CORRECTION NOTICE

LAKE LOTHING (LOWESTOFT) THRD CROSSING ORDER 2020 (S.I. 2020 No. 474)

SCHEDULE 4 TO THE PLANNING ACT 2008 CORRECTION OF ERRORS IN DEVELOPMENT CONSENT DECISIONS

21 October 2020

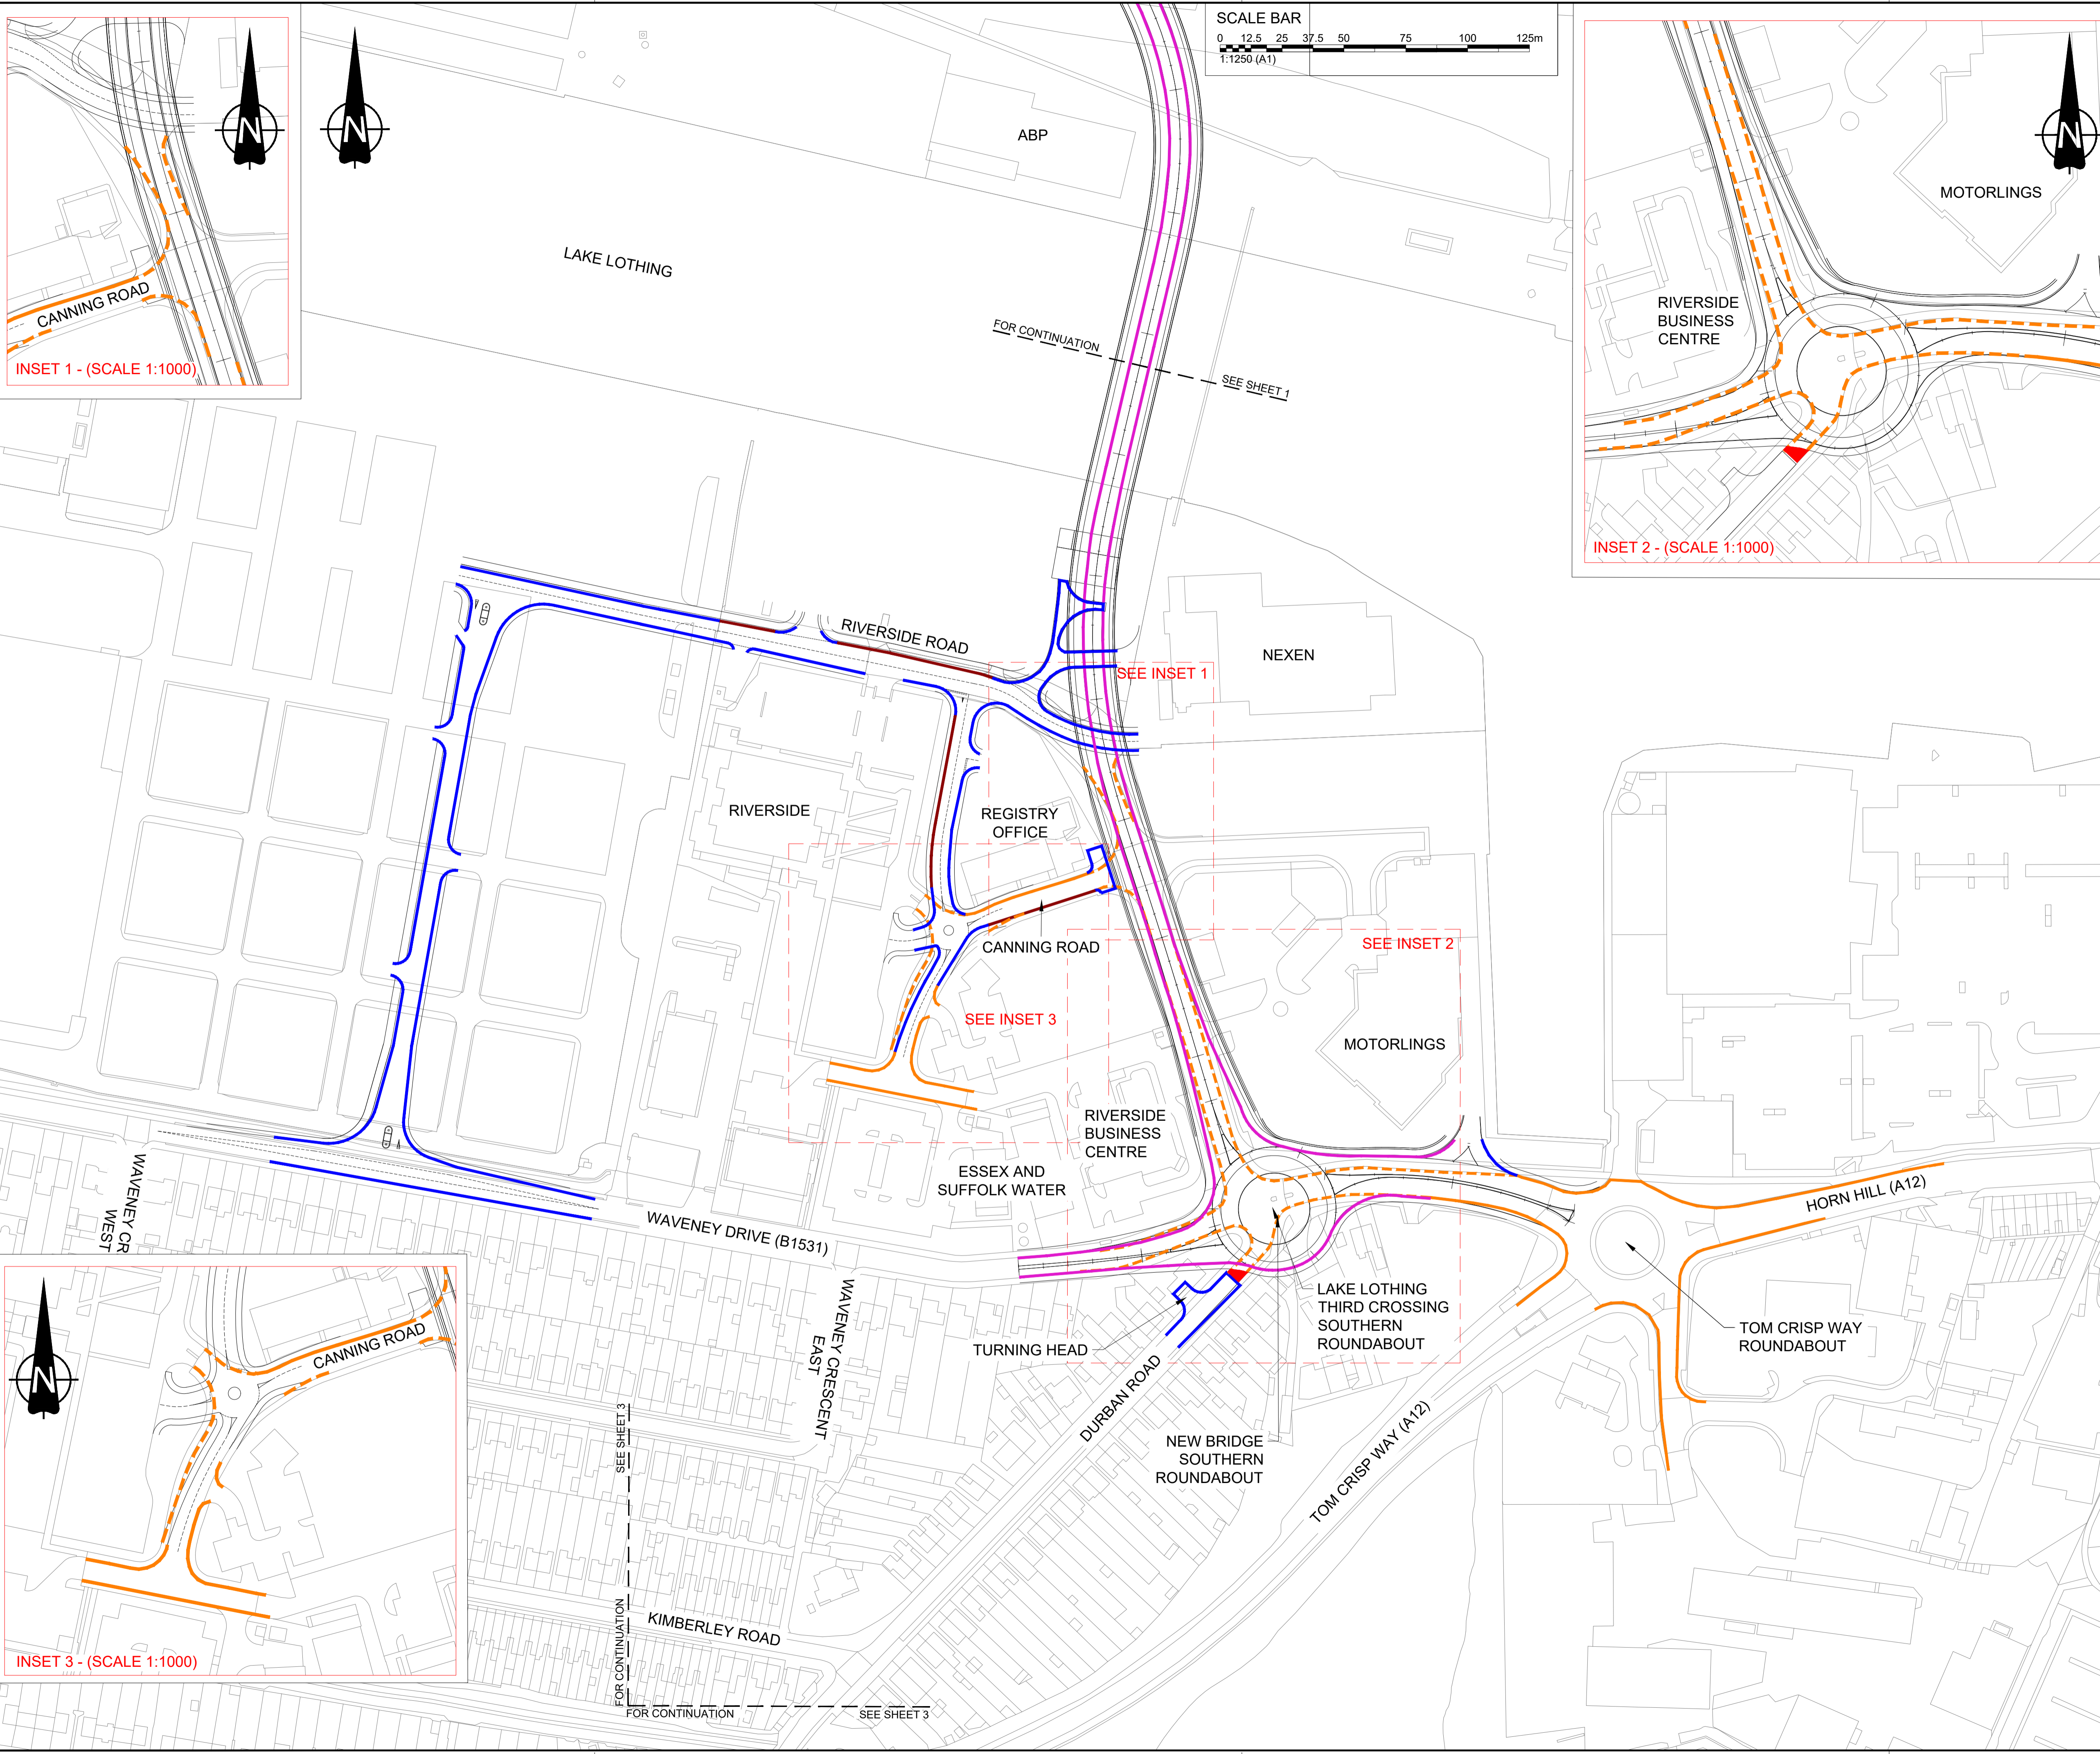
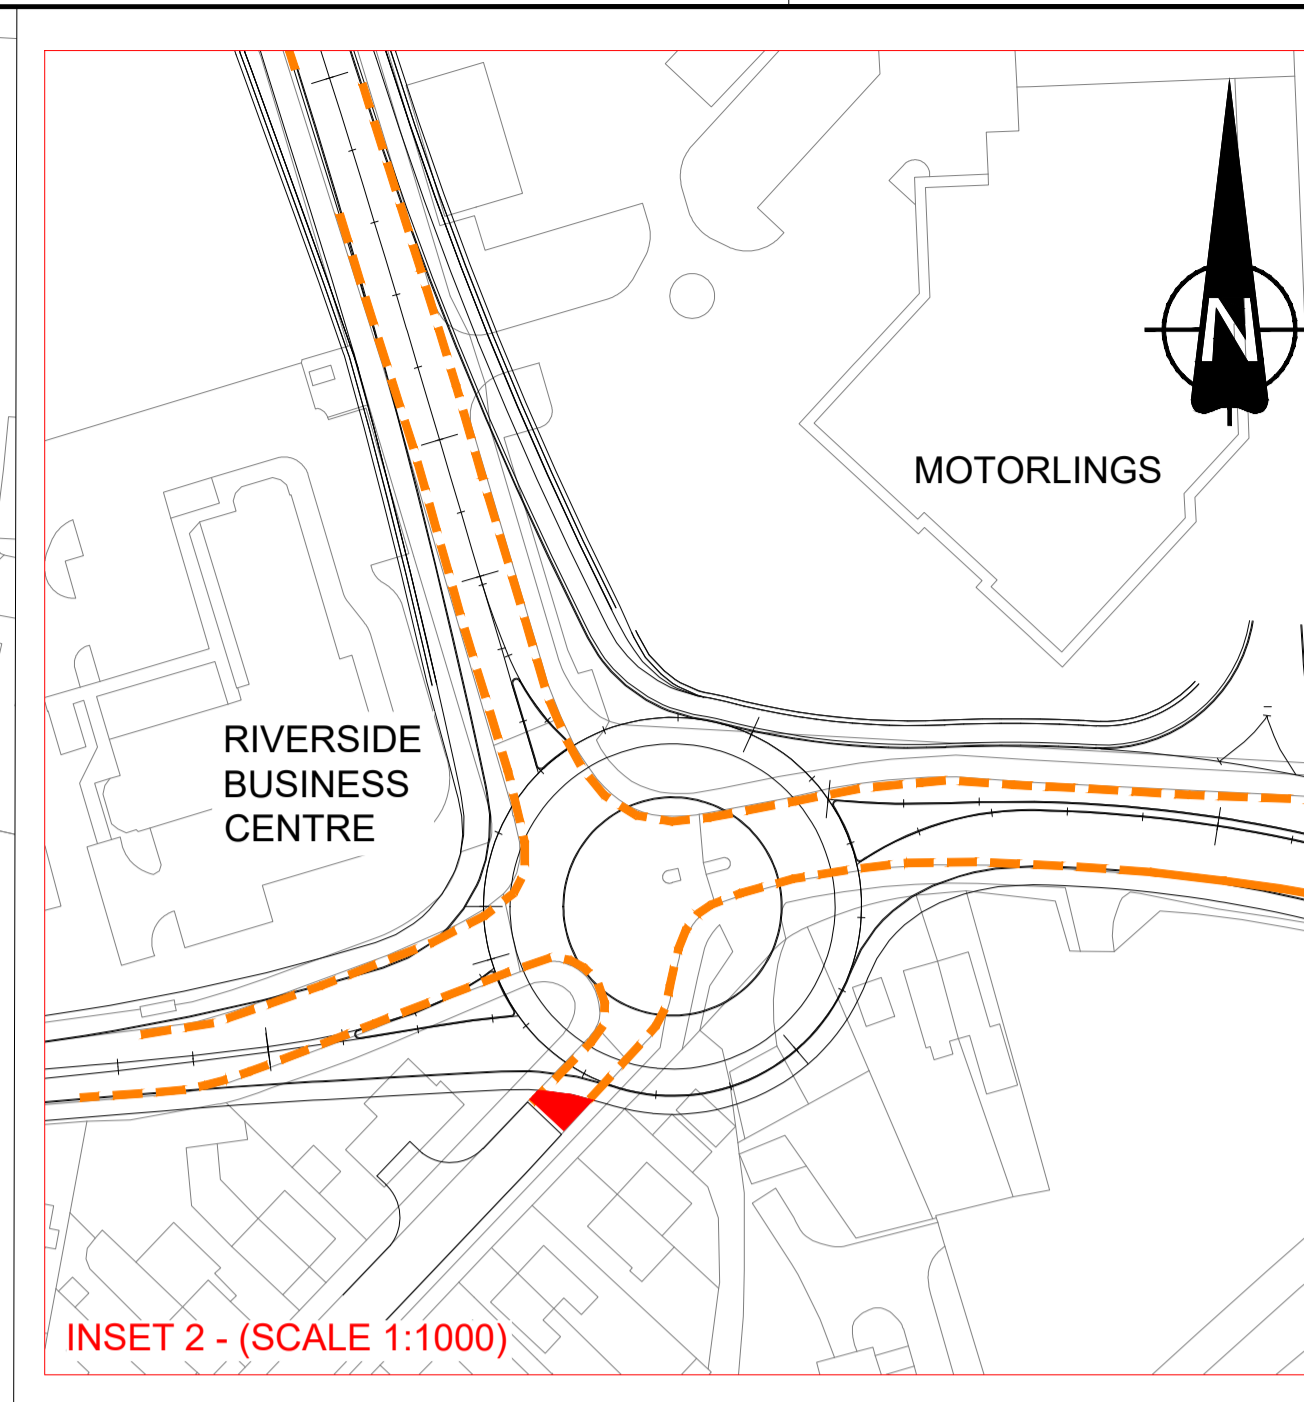
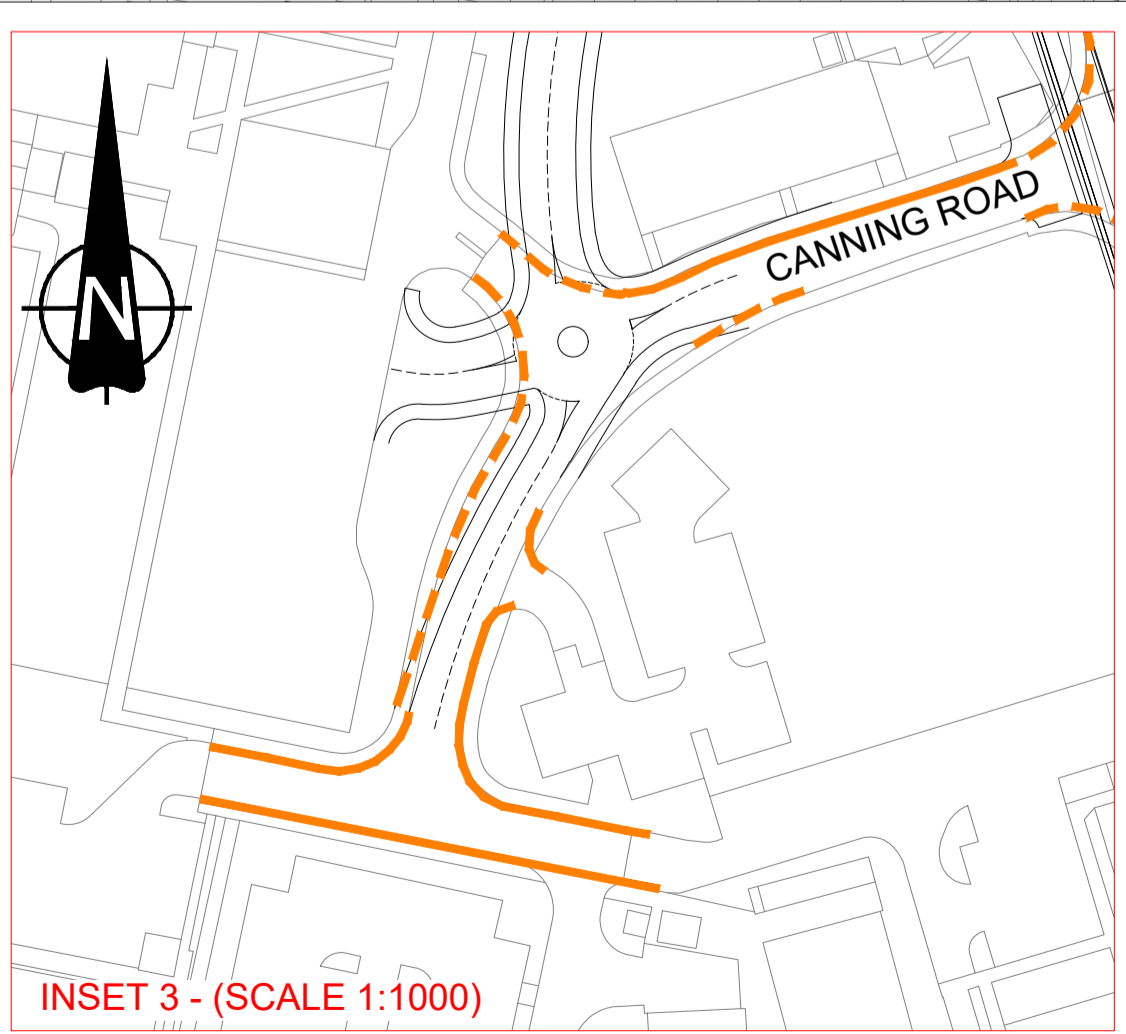
In the thirteenth row (the entry relating to the second reference of "Canning Road") below sub-heading "The traffic regulation measures plans (clearways and prohibitions) – sheet 2", in column (2) of that row replaced "8" with "10", "9" with "7", and "being" with "including".

Secretary of State's rationale: To correct factual errors in the description of the road.
